PLAN REVIEW SHEET

FIRST SUBMITTAL

CATS acknowledges receipt of the rezoning application and site plan and submits the following to the petitioner:

PROJECT NO: VSL-08010  
 FILENAME: VSL08010-TD  
 DESIGNED BY: CSS  
 DRAWN BY: CSS  
 SCALE: 1"=40'  
 DATE: 06/23/2008  
 SHEET NO: **TD-1**

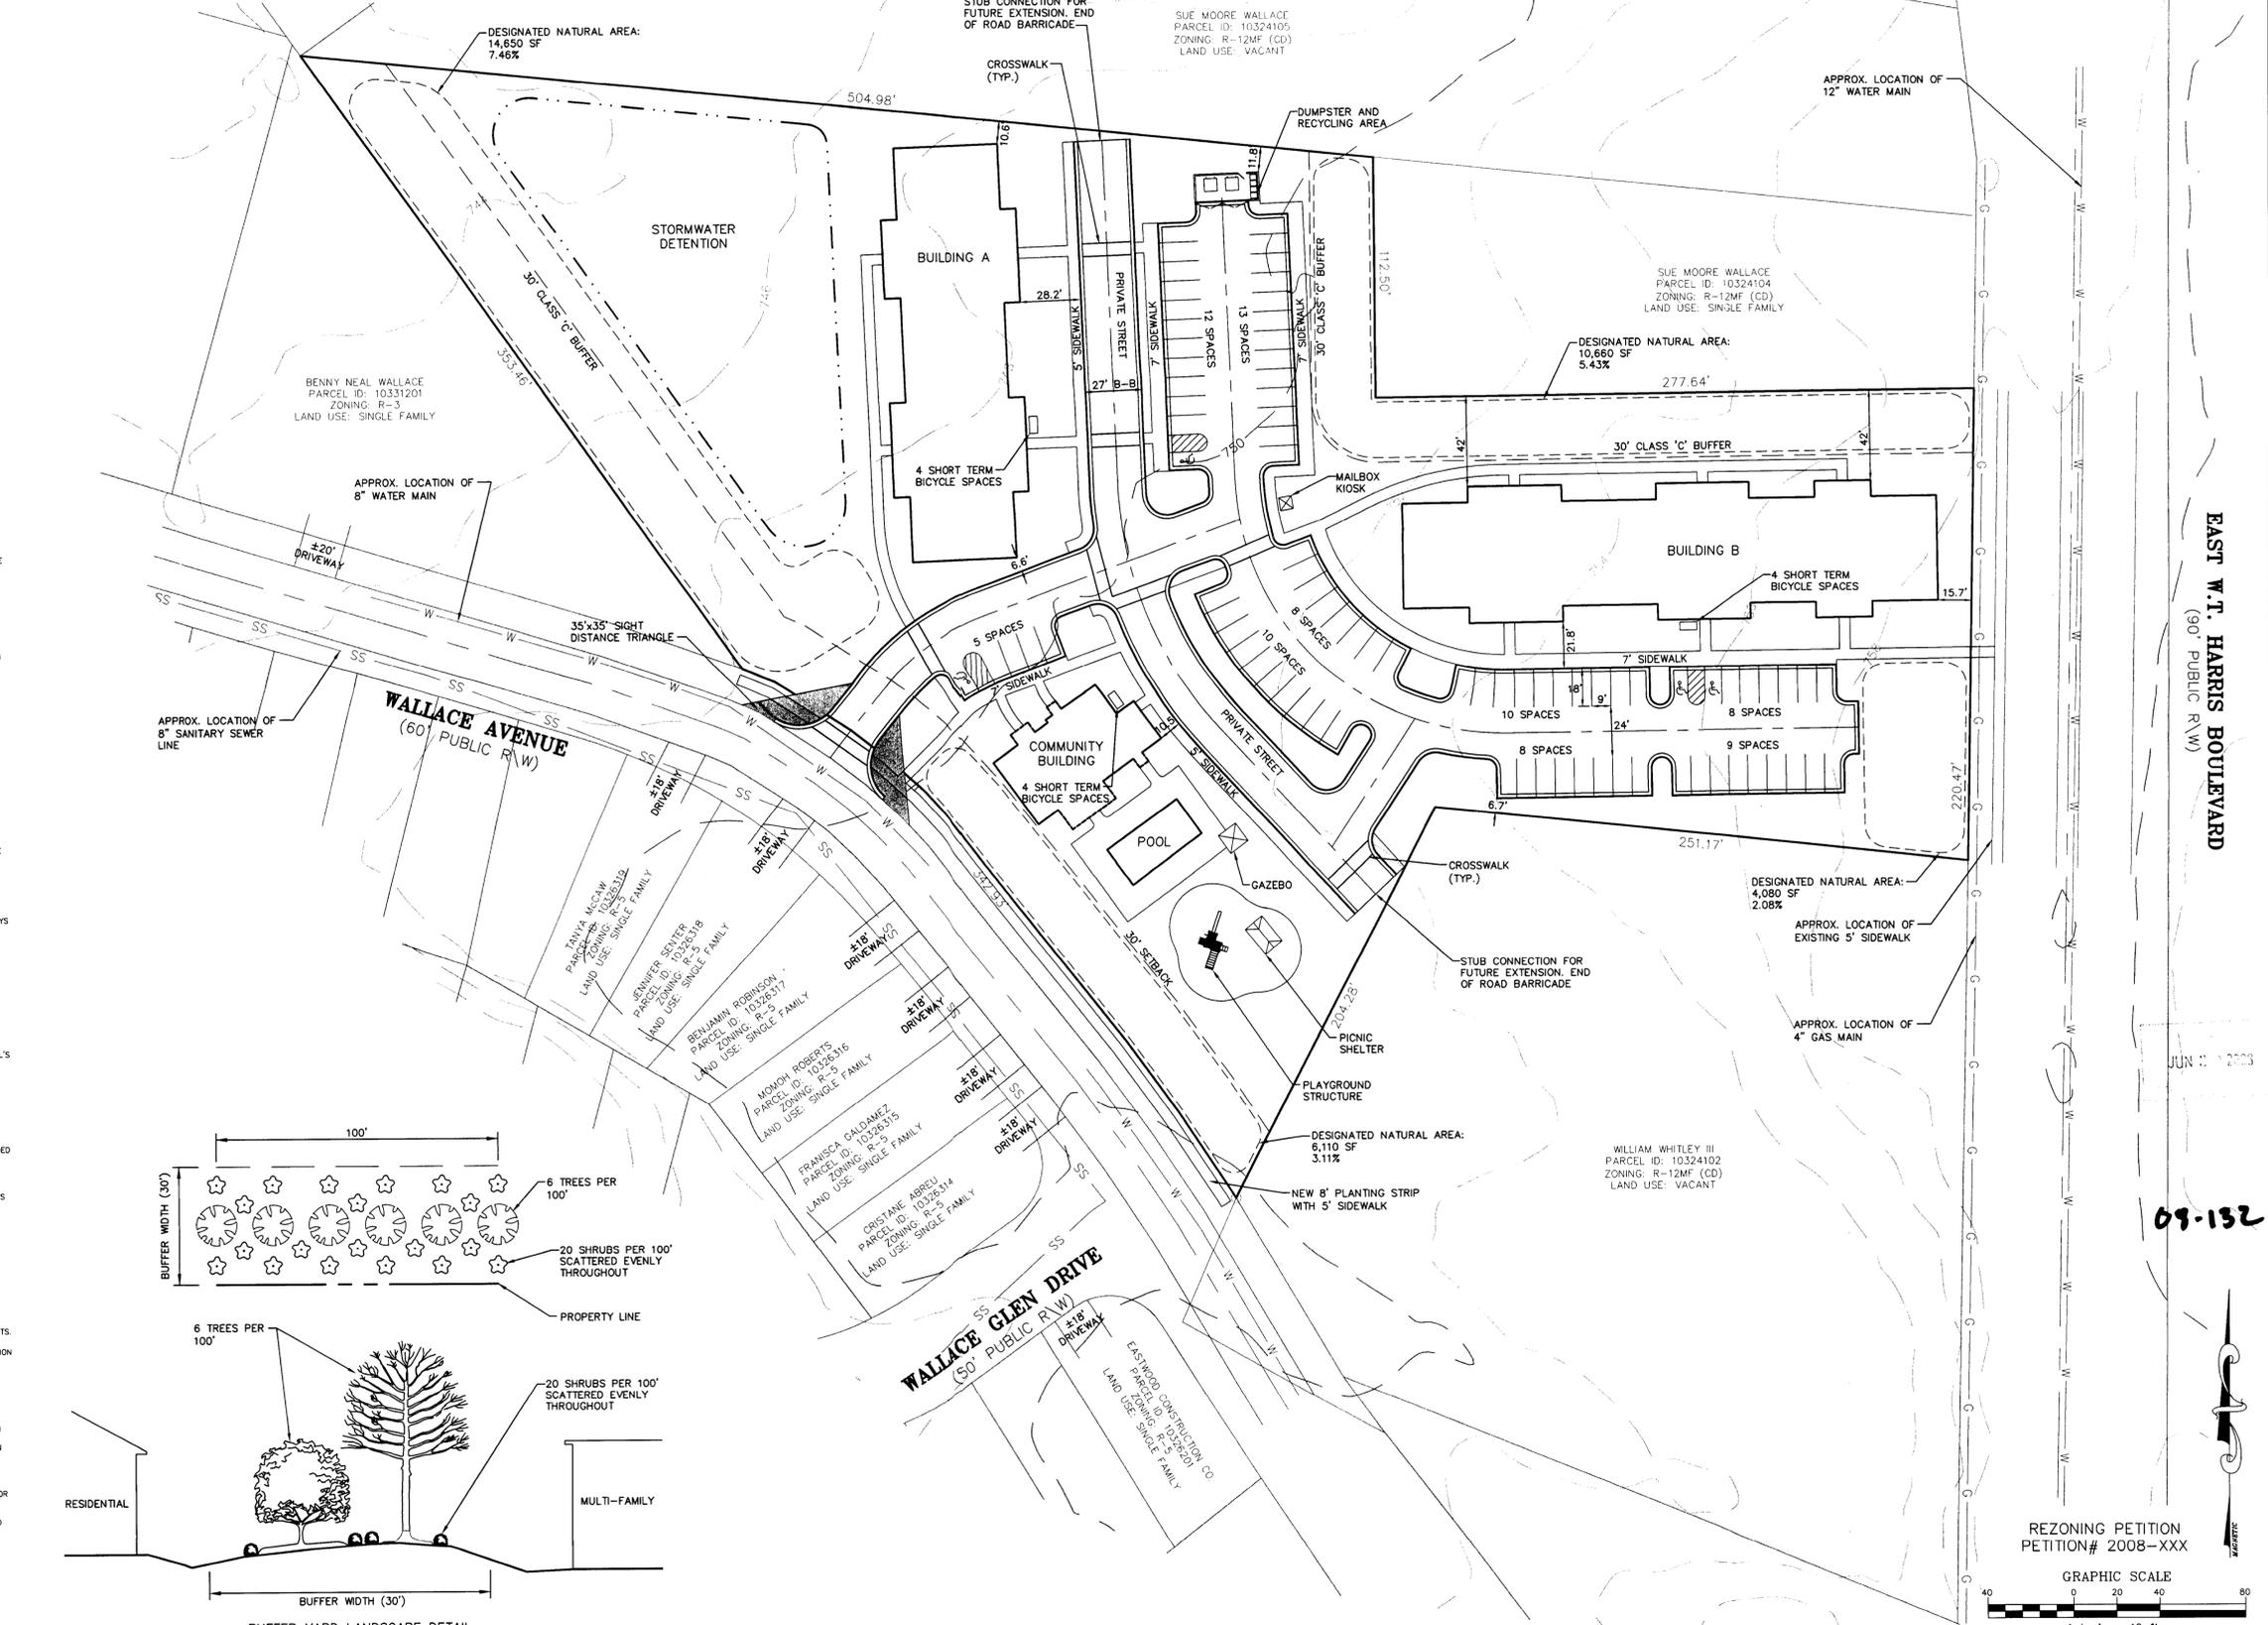
- 1) The petitioner’s site is currently served by Route 222 Pence Road.
2) CATS supports CDOT’s memorandum comment regarding sidewalk along East WT Harris Boulevard:
3) CATS requests the petitioner to construct a concrete shelter pad on E WT Harris Boulevard at the location of the existing bus stop (CATS Stop ID# 45235), constructed to CATS Development Standards 60.03 A (see attached).

Please designate such in the site plan and/or accompanying notes. Please contact Leonard Ganther (CATS Operations) @ 704.432.1283 prior to demolition or construction to coordinate the final location of the shelter pad.
